<b>Application Ref:</b>	2025/0407			 <b>Ribble Valley Borough Council</b> <a href="http://www.ribblevalley.gov.uk">www.ribblevalley.gov.uk</a>				
<b>Date Inspected:</b>	12/08/2025	<b>Site Notice:</b>	N/A					
<b>Officer:</b>	EP							
<b>DELEGATED ITEM FILE REPORT:</b>					<b>APPROVAL</b>

<b>Development Description:</b>	Proposed extension of rear dormer, new front dormer, single storey rear extension and new front porch.
<b>Site Address/Location:</b>	1 Eastfield Drive West Bradford BB7 4TQ

**PROPOSED REAR ELEVATION**  
SCALE - 1:50 @ A1

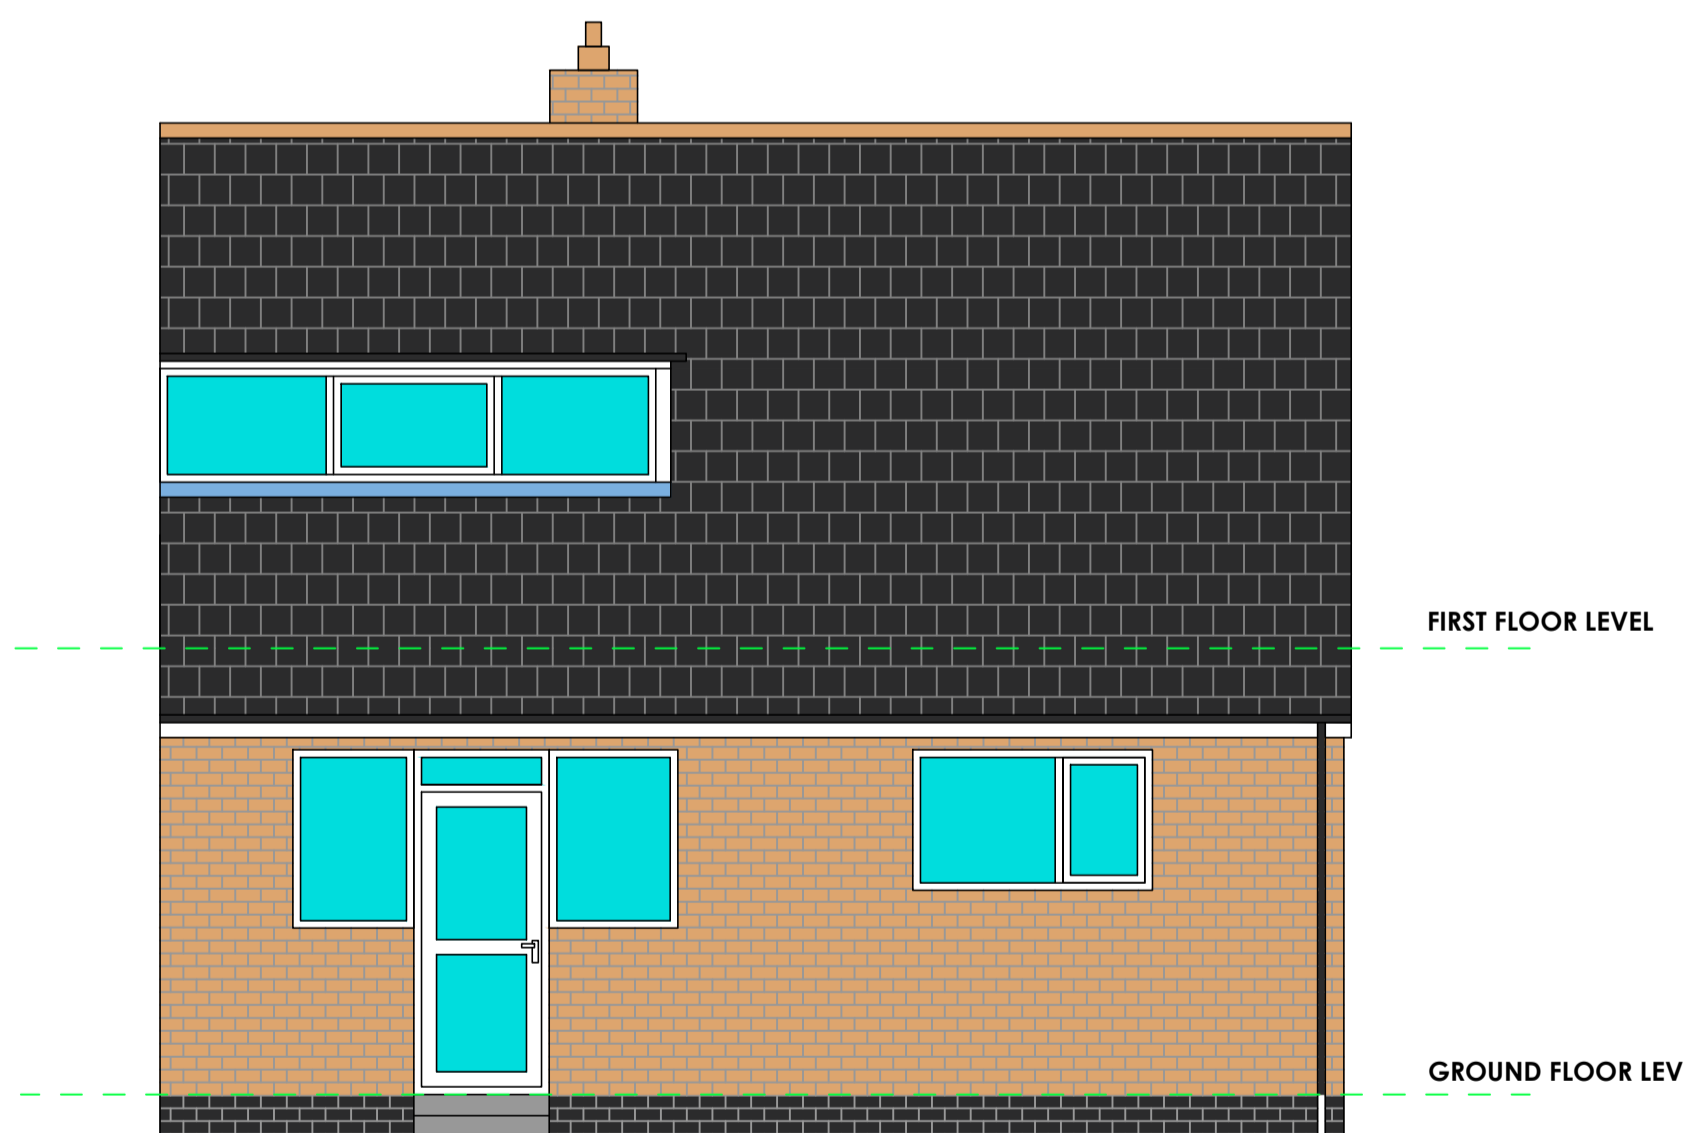
The proposed rear dormer will have additional window opening facing two properties located to the rear of the application site, No.2 and No.4 Hillside Drive. There is a sufficient privacy distance between habitable windows of approximately 25m to mitigate any potential for overlooking. Furthermore, a similar dormer can be constructed utilising permitted development rights.

The proposed rear dormer extension is a continuation of an existing dormer. Whilst the dormer will be larger in scale, the overall projection is modest and will not read as a dominant addition to the host dwelling.

The proposed rear extension is again modest in footprint, measuring 3m in depth from the rear elevation of the property. The extension projects slightly beyond the eaves of the existing dwelling and therefore could not be constructed under permitted development. However, besides this, the development largely complies with the allowance for PD. As such, the proposal raising no concerns from a scale or design perspective.

**PROPOSED FIRST FLOOR PLAN**  
SCALE - 1:50 @ A1

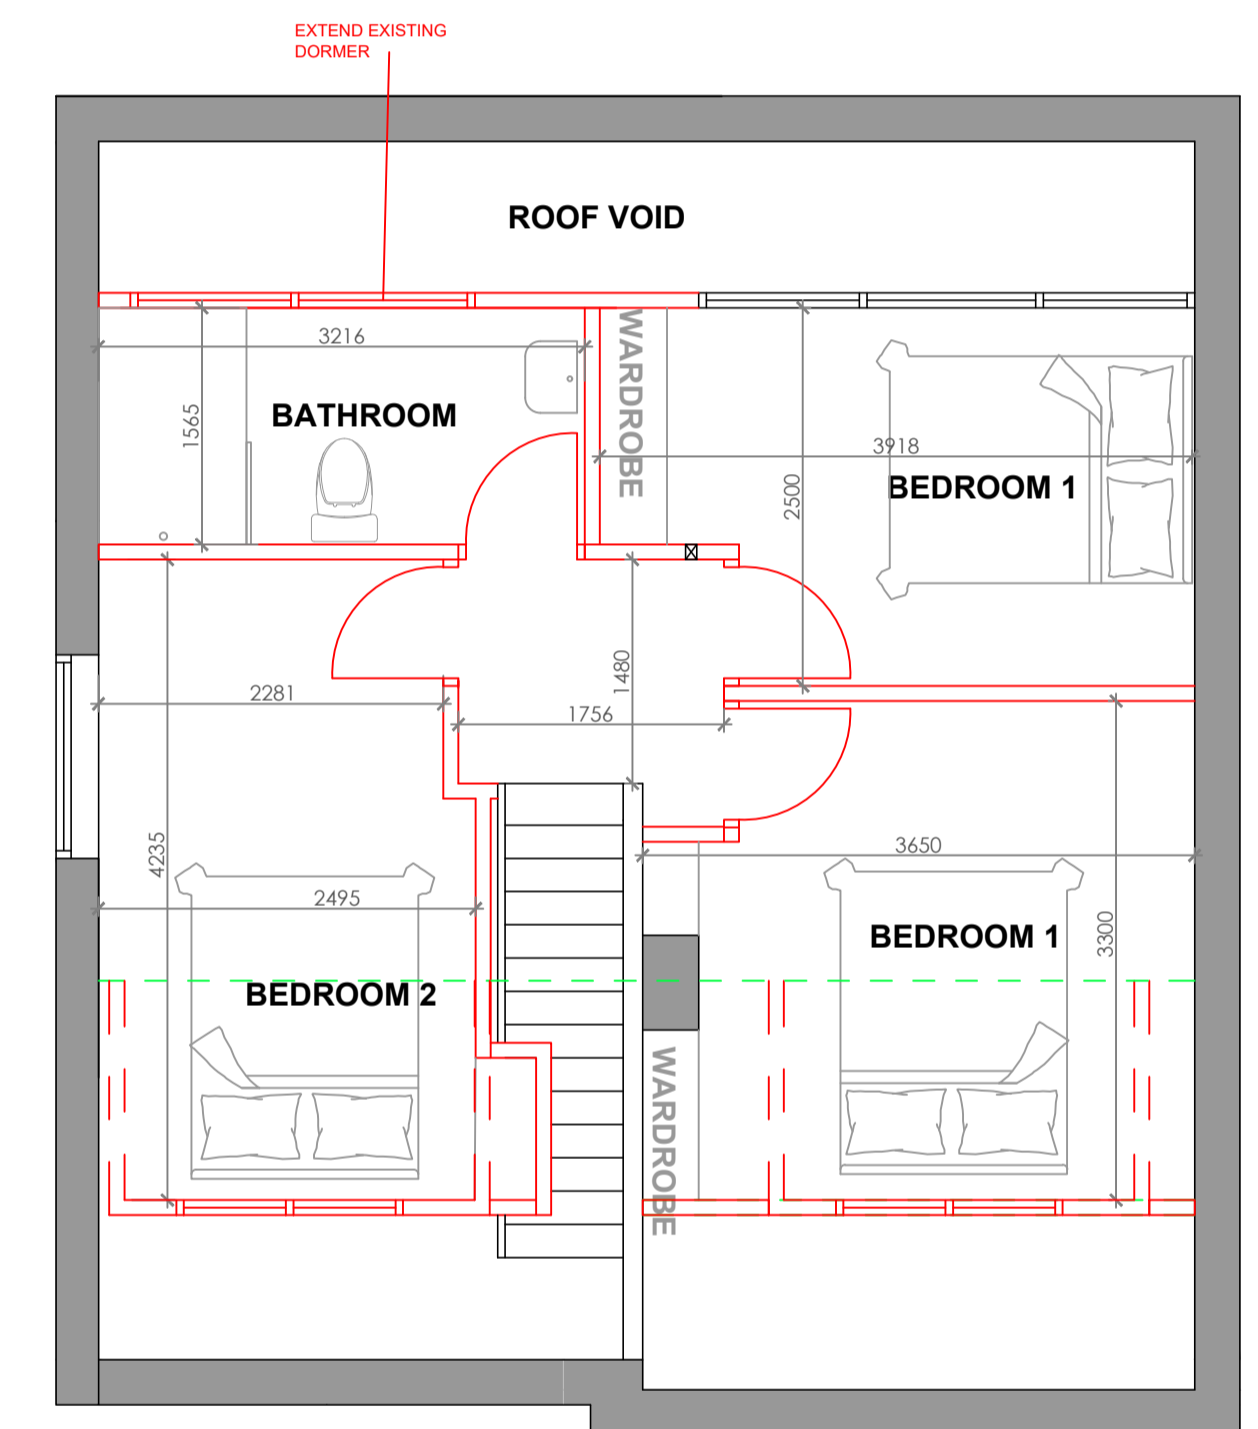
The proposed front dormer extension will result in the introduction of new window openings to the principal roof slope. The nearest receptors of the east are in excess of 24m from the proposal and therefore the front dormers do not raise concern in respect to loss of privacy.

The proposed front dormer extension will host a prominent position being located on the principal roof slope. The overall scale and proportions of the dormer extension is modest in relation to the roof slope. They are also similar in size to other front dormer extensions found within the vicinity.

PROPOSED SITE PLAN

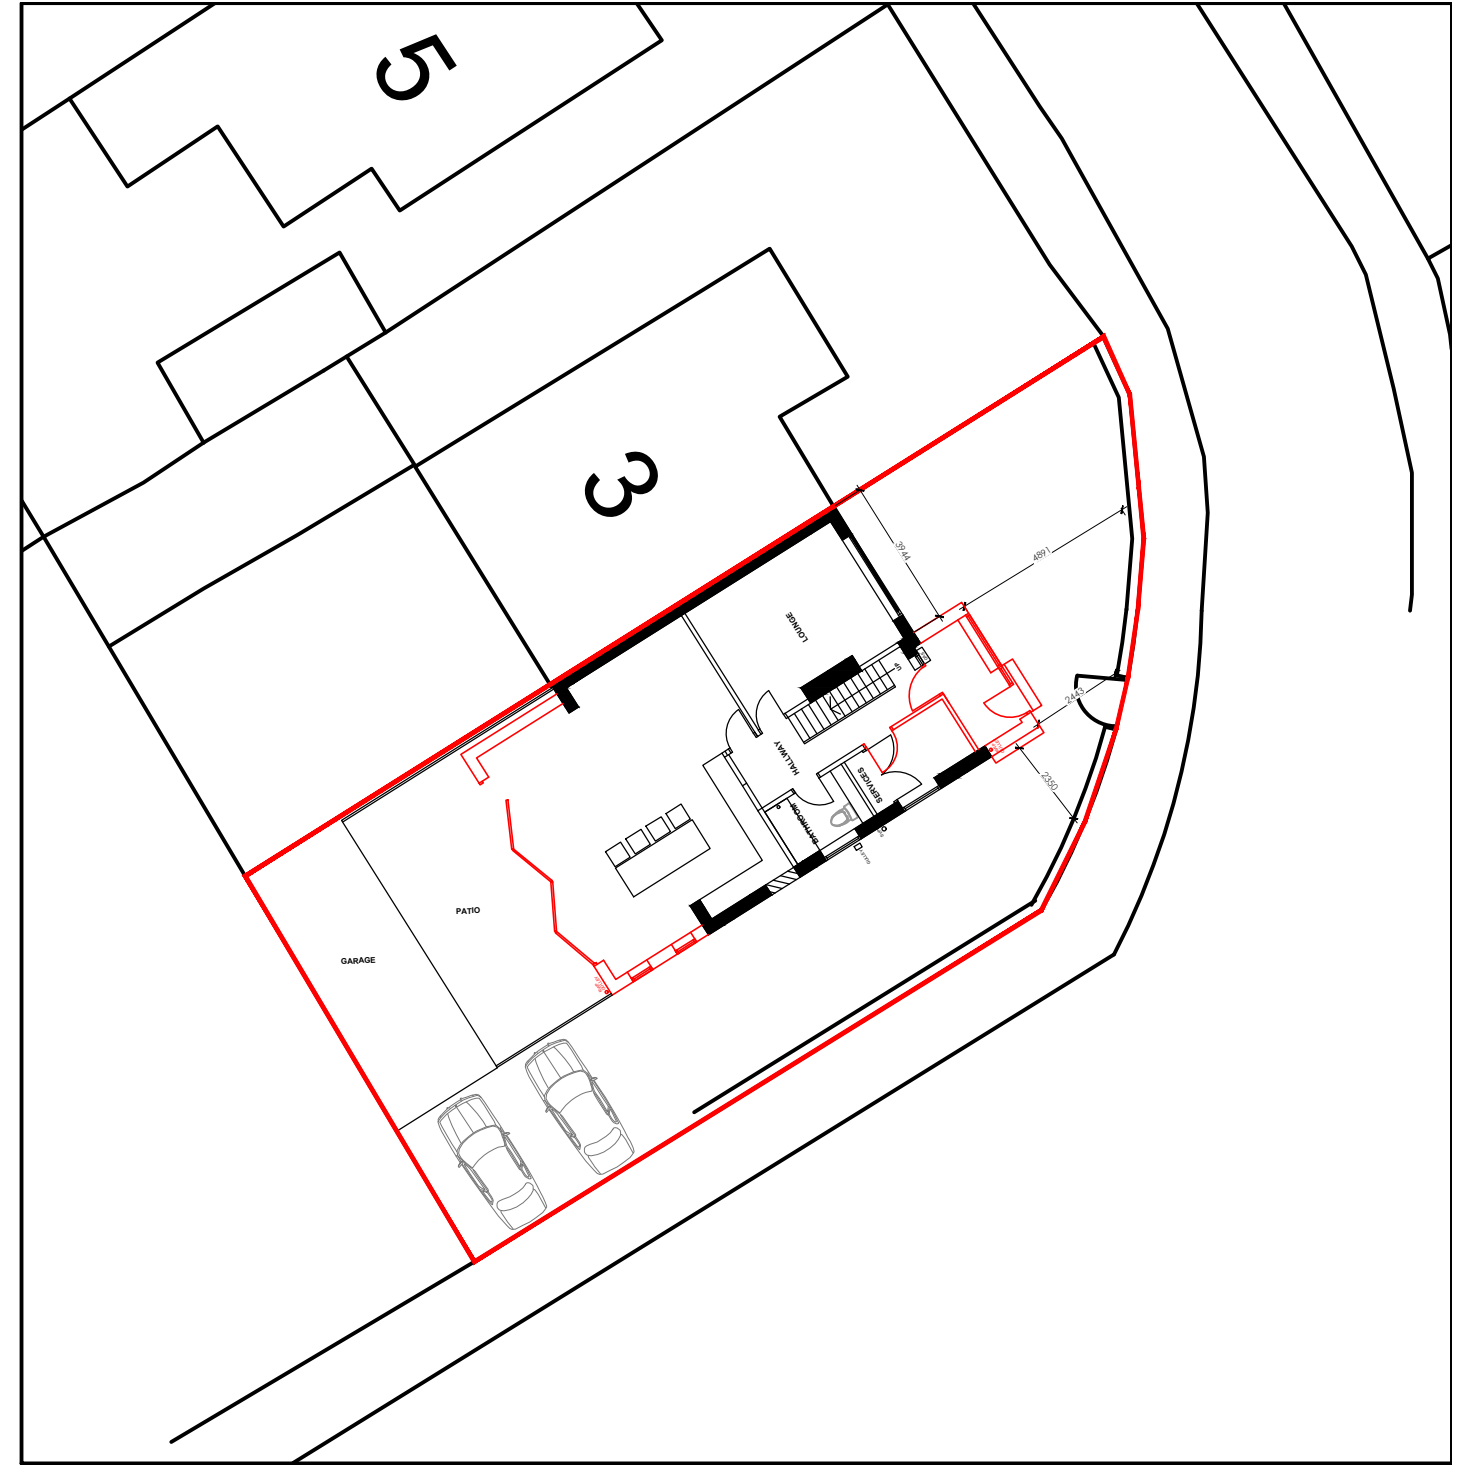
<b>CONSULTATIONS:</b>	<b>Parish/Town Council</b>
The parish council raised concerns over the loss of a parking space within the site and subsequent on street parking.

LCC Highways were consulted in relation to the proposal and responded requesting confirmation that the site can maintain two off road parking spaces.

An amended site plan has been received which confirmed that two of the off-road spaces would be retained in line with parking standards.
